KITTITAS COUNTY

MEMORANDUM

TO: All Staff
FROM: Public Works Plan Review Team
DATE: December 9, 2022
SUBJECT: SE-22-00065 Bowers Field Ph 1

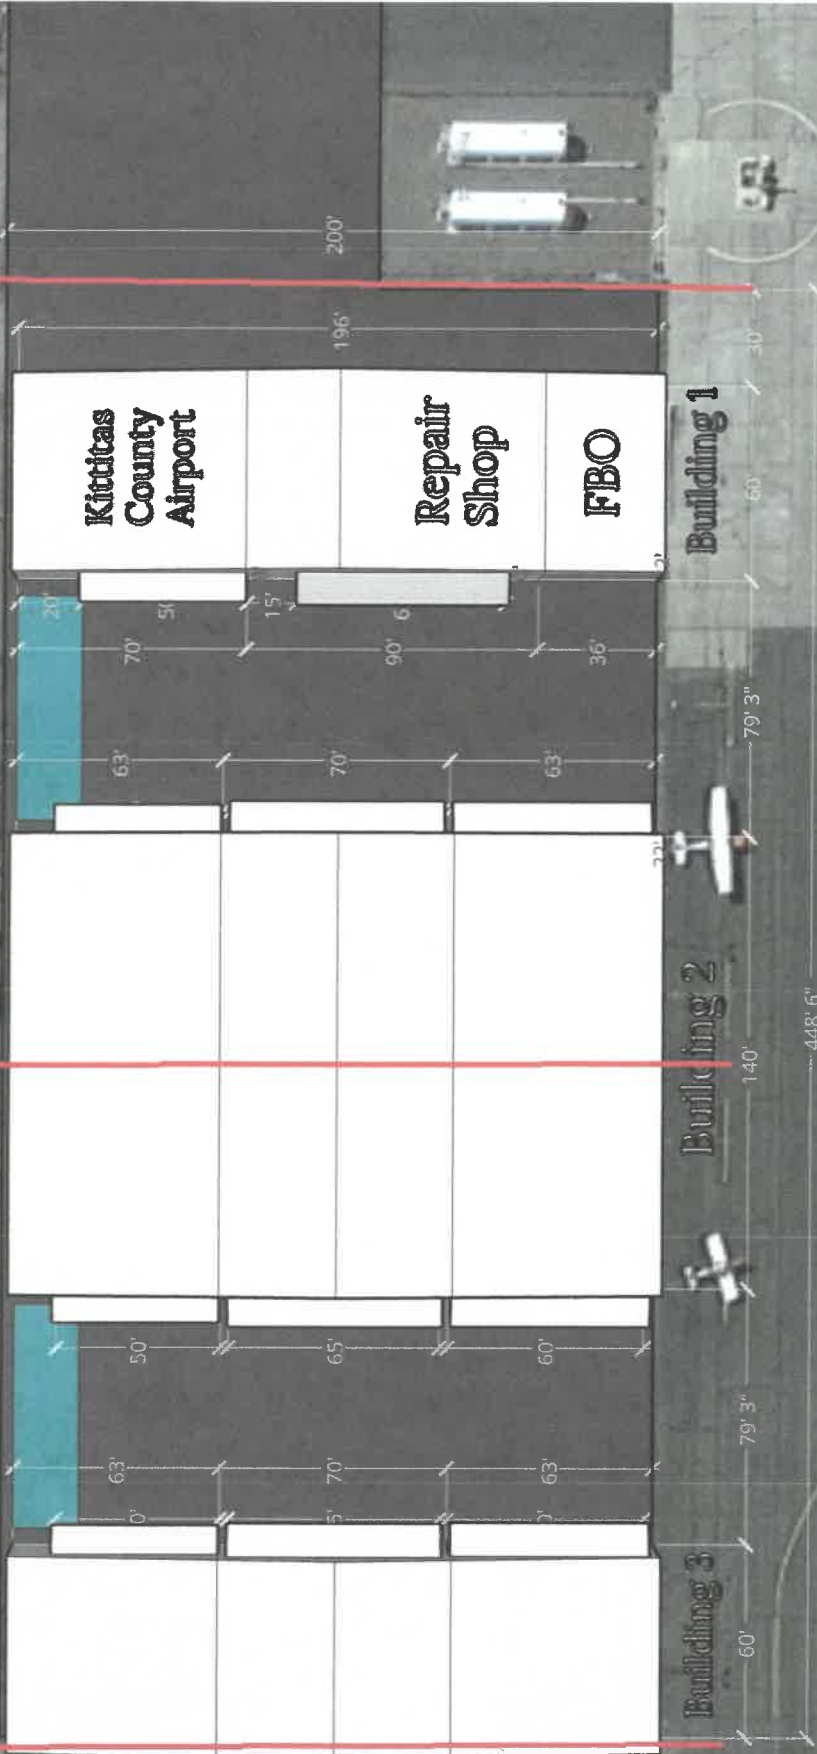
SURVEY	<ol style="list-style-type: none"> 1. Construction shall take Airport restrictions into consideration, and no vertical penetration into height restricted zones shall be allowed. 2. Applicant is hereby notified that there are likely underground facilities in the proposed new building footprints that will need to be relocated.
FLOOD	<p>Best available information indicates that this property is at flood risk and that upcoming flood mapping changes are expected to include property within the 100-year floodplain. A floodplain development permit is not currently required because the effective Flood Insurance Rate Map does not yet include the project location. If the flood maps are revised prior to building permit <u>issuance</u> then a flood permit will be required. The applicant is encouraged to work with Public Works proactively to address flood risk, as indicated by best available information.</p>
